**Date:** 09/22/2023

**Re:** **Damaged Roof Truss**  
Location: Lot 68 Serenity (67 Contentment Lane Fuquay-Varina, NC)  
JDS Project No.: RDU2308841  
Date of Inspection: 09/22/2023

Roof Plan
Elevation "B"

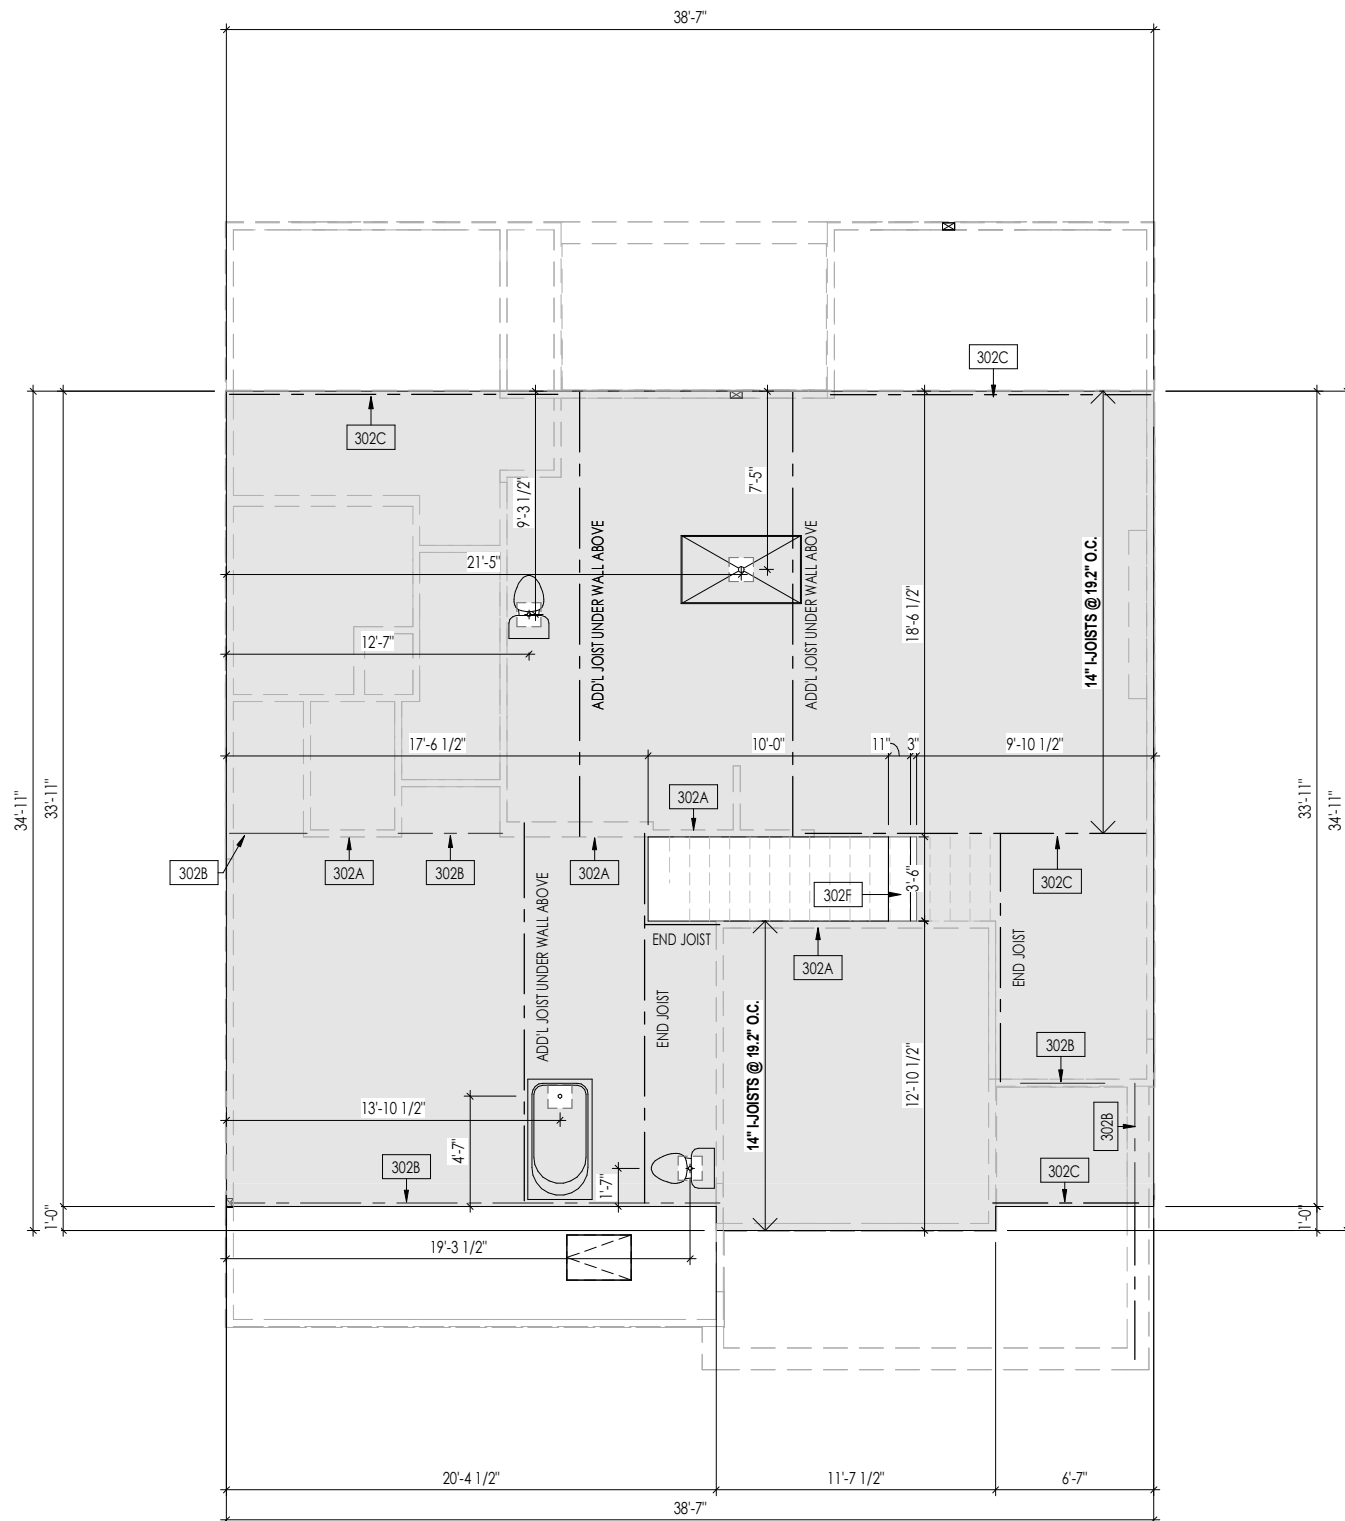
The client requested an evaluation of the 1<sup>st</sup> roof truss from the front gable, located above the garage which is damaged at the rear side of the bottom chord at joint 7.

Based on our on-site evaluation and review, install (1) 2x4 4'0" length scab on both sides of the bottom chord starting at joint 7 and attach it with (2) rows of 10d nails spaced 6" o.c.
